# Final Plat Comments - ELY responses.pdf Markup Summary

**Subject:** Text Box  
**Page Label:** Sheet 1 - Cover  
**Author:** dsdlaforce  
**Date:** 9/30/2021 3:41:57 PM  
**Status:**  
**Color:** ■  
**Layer:**  
**Space:**

**Subject:** Text Box  
**Page Label:** Sheet 3 - Replat  
**Author:** dsdlaforce  
**Date:** 9/21/2021 2:21:33 PM  
**Status:**  
**Color:** ■  
**Layer:**  
**Space:**

# CROSSROADS MIXED USE FILING NO. 1

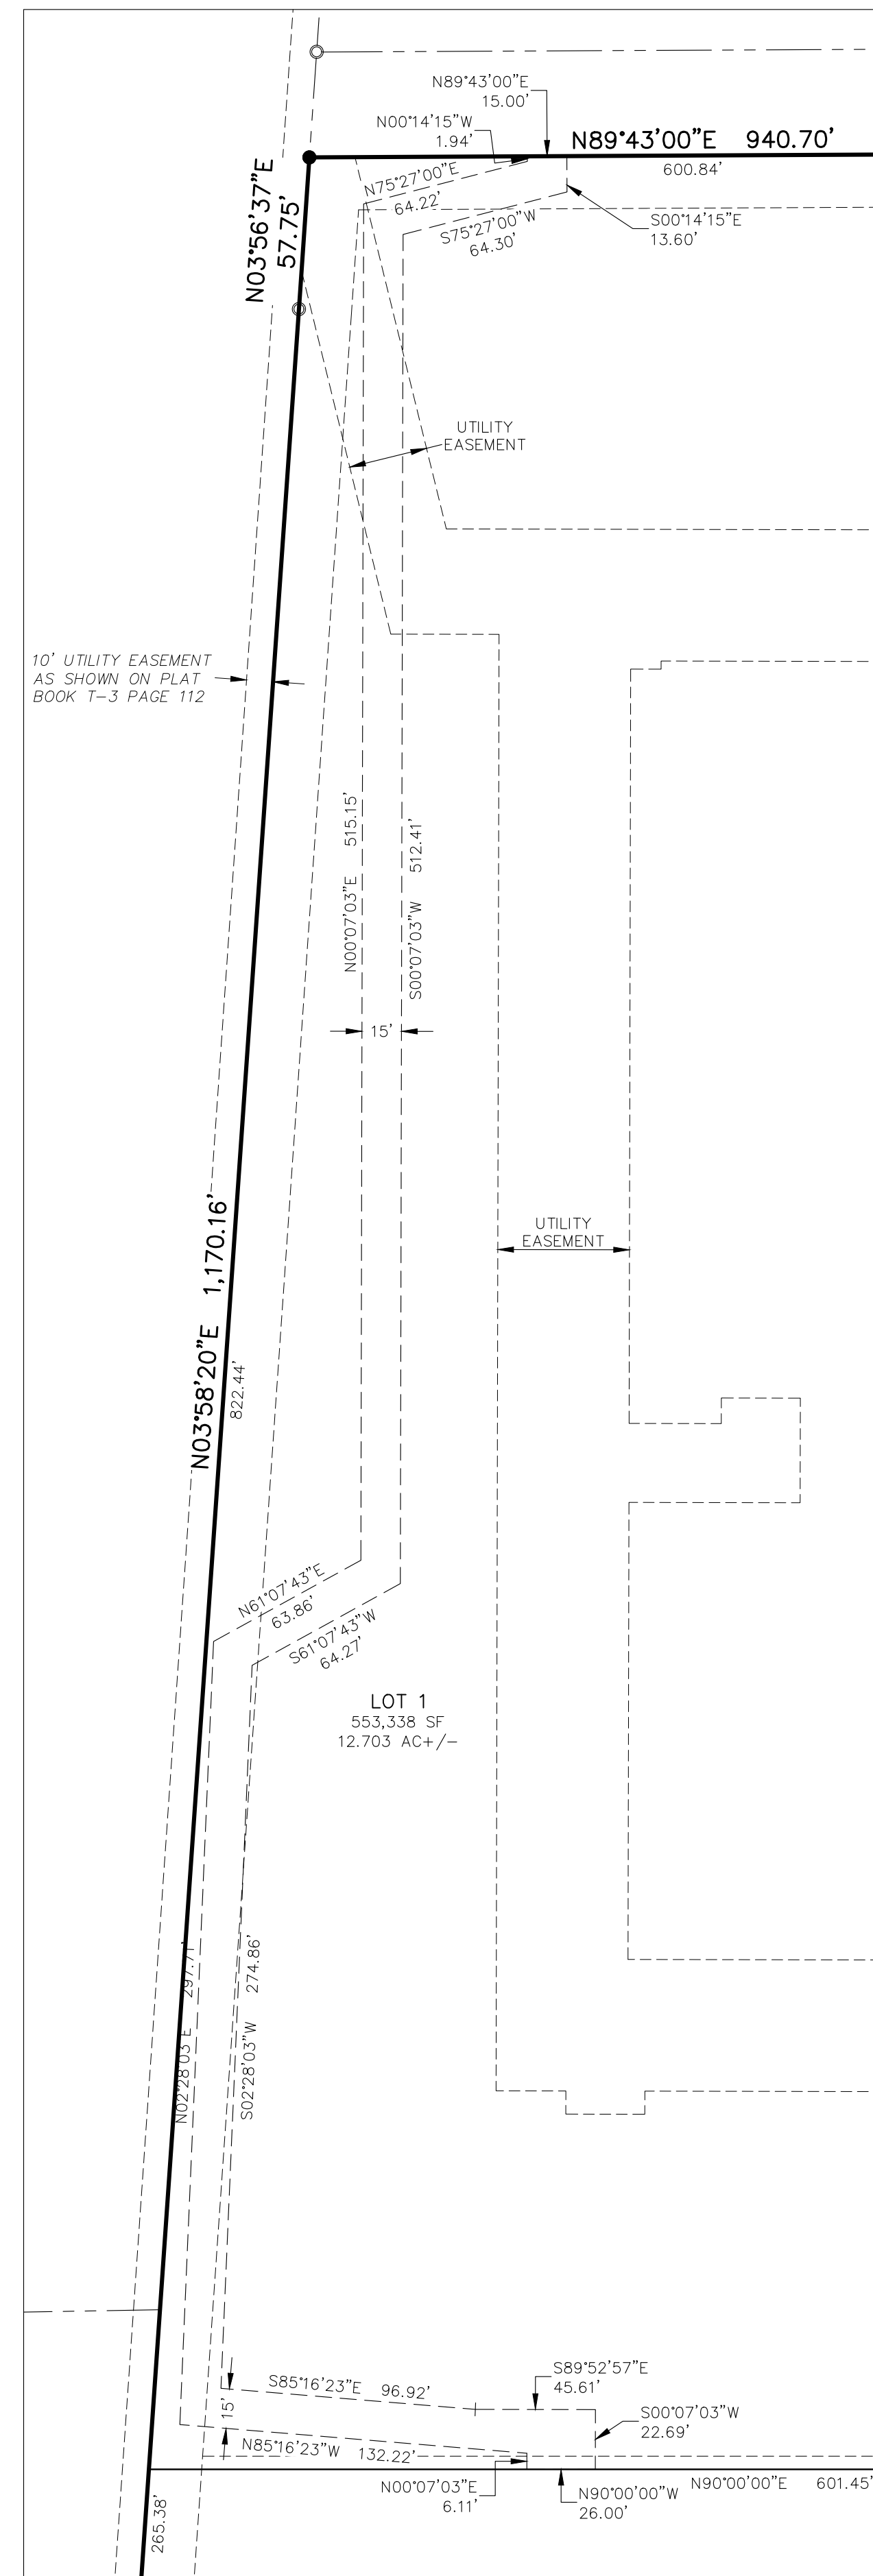
Based on CDOT comments to the preliminary plan, CDOT is requesting additional ROW along Highway 24 for the future improvements along highway 24. From discussions with CDOT, they are requesting the applicant submit an exhibit showing the full buildout configuration at the intersection and the corresponding ROW dedication that may be needed.

Coordinate with CDOT regarding the offsite improvements and their requirements.

CDOT request not addressed at this time.

It may be beneficial to provide an additional "utility easement" label here for clarity

Additional label added.

Label this as a private road per preliminary plan

Private road added to label.

**PRIVATE STORM DRAIN EASEMENT DETAIL**  
SCALE: 1" = 50'  
TO BE MAINTAINED BY  
CROSSROADS METROPOLITAN DISTRICT NO. 1

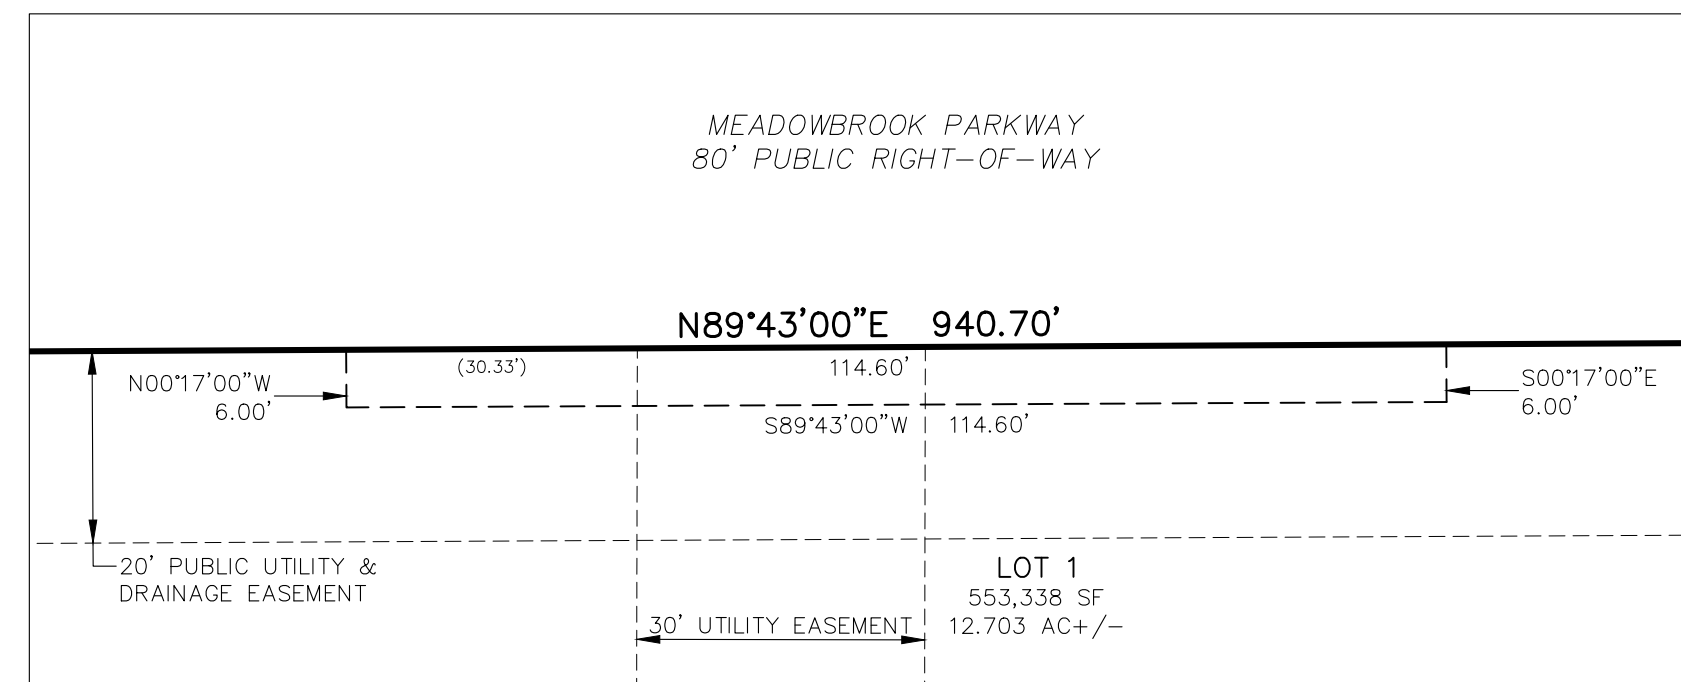
Provide a drainage easement for the stormdrain line conveying the stormwater from Meadowbrook Parkway through Lot 11 and into Tract A. This needs to be identified as private/maintained by CMD1

Drainage easement added. Easement metes and bounds are shown in a detail on sheet 4 for clarity. Identified as to be maintained by Crossroads Metropolitan District No. 1.

**PUBLIC RIGHT-OF-WAY DEDICATION DETAIL PROW-2**  
1,022 SF - 0.023 AC +/-  
SCALE: 1" = 20'

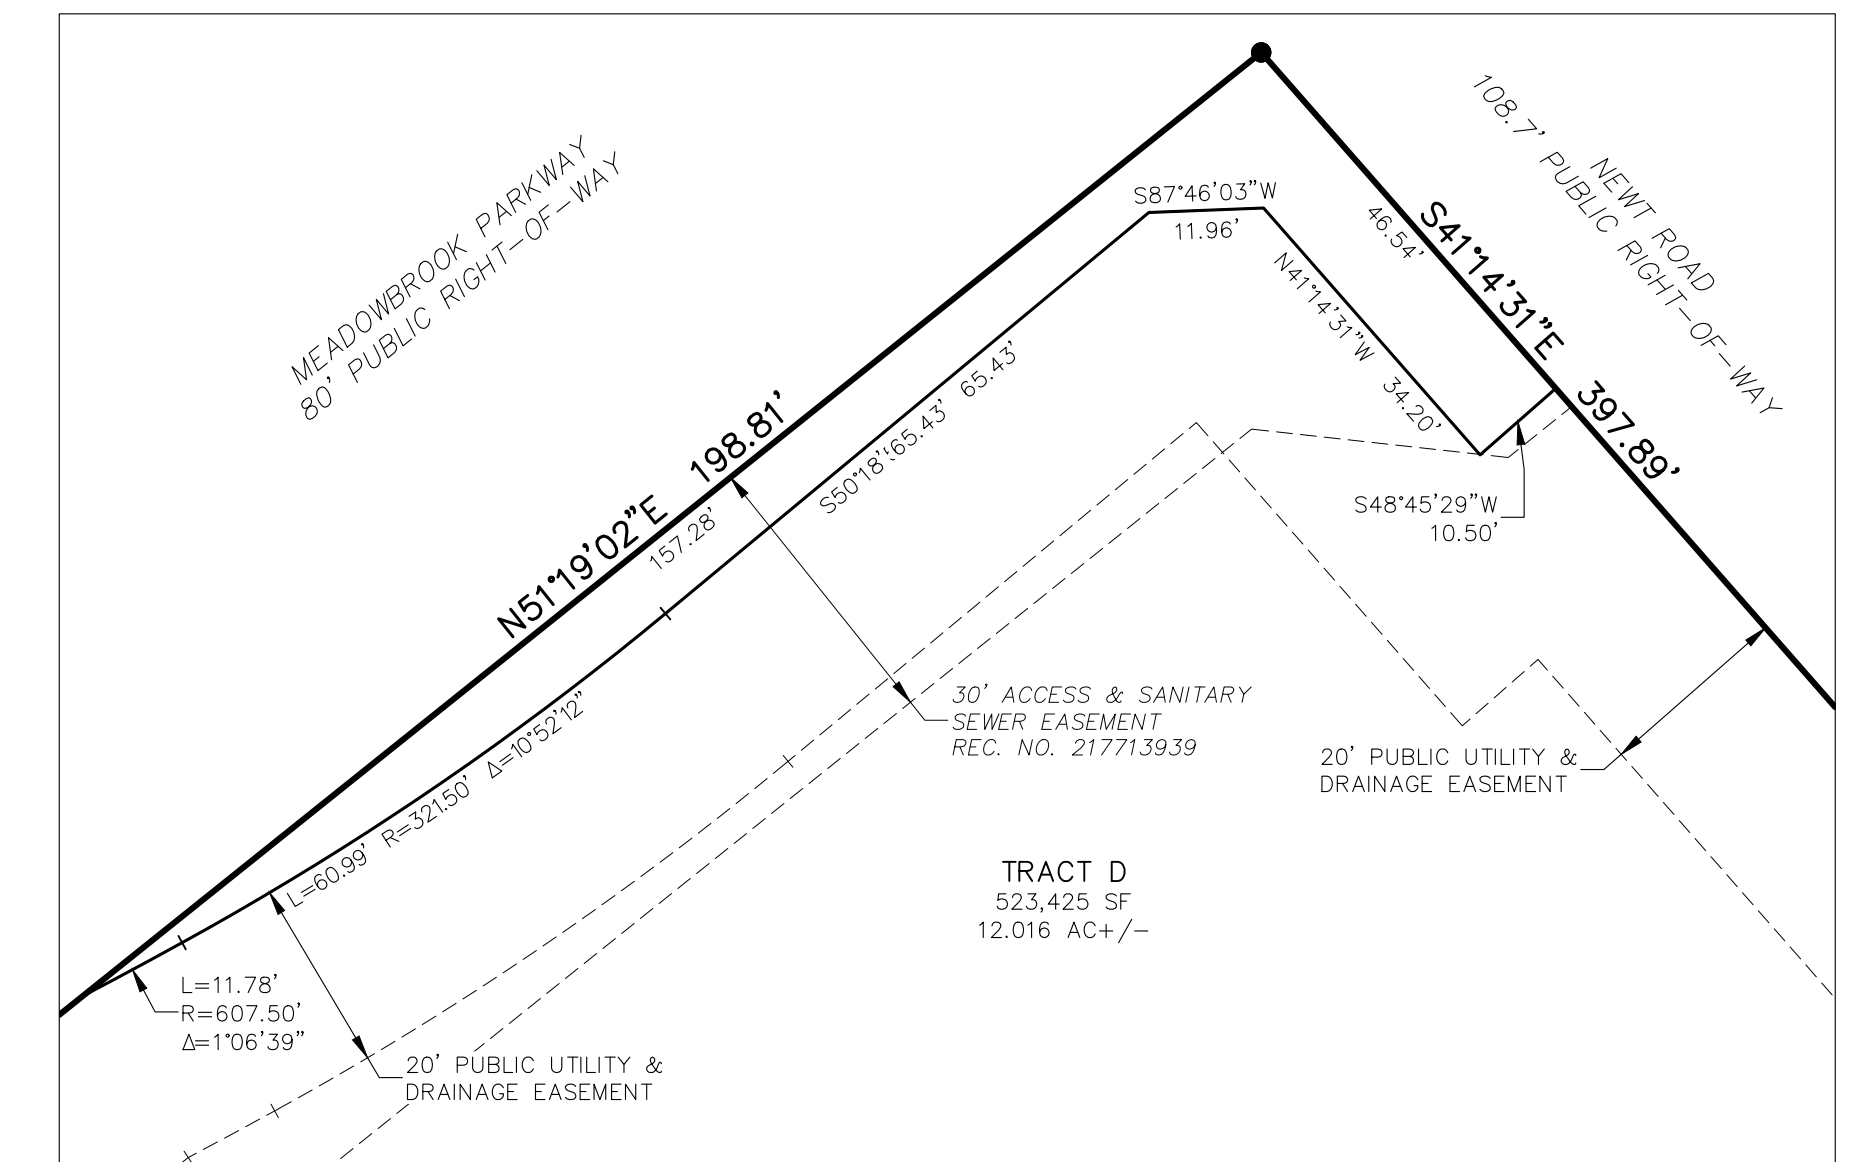
Revise to ROW. See redline comments on the construction drawings.

Public improvement easement converted to right-of-way.  
Due to the small size of the area to be dedicated, it is shown as a detail on sheet 4.  
(Former Detail PIE-4)
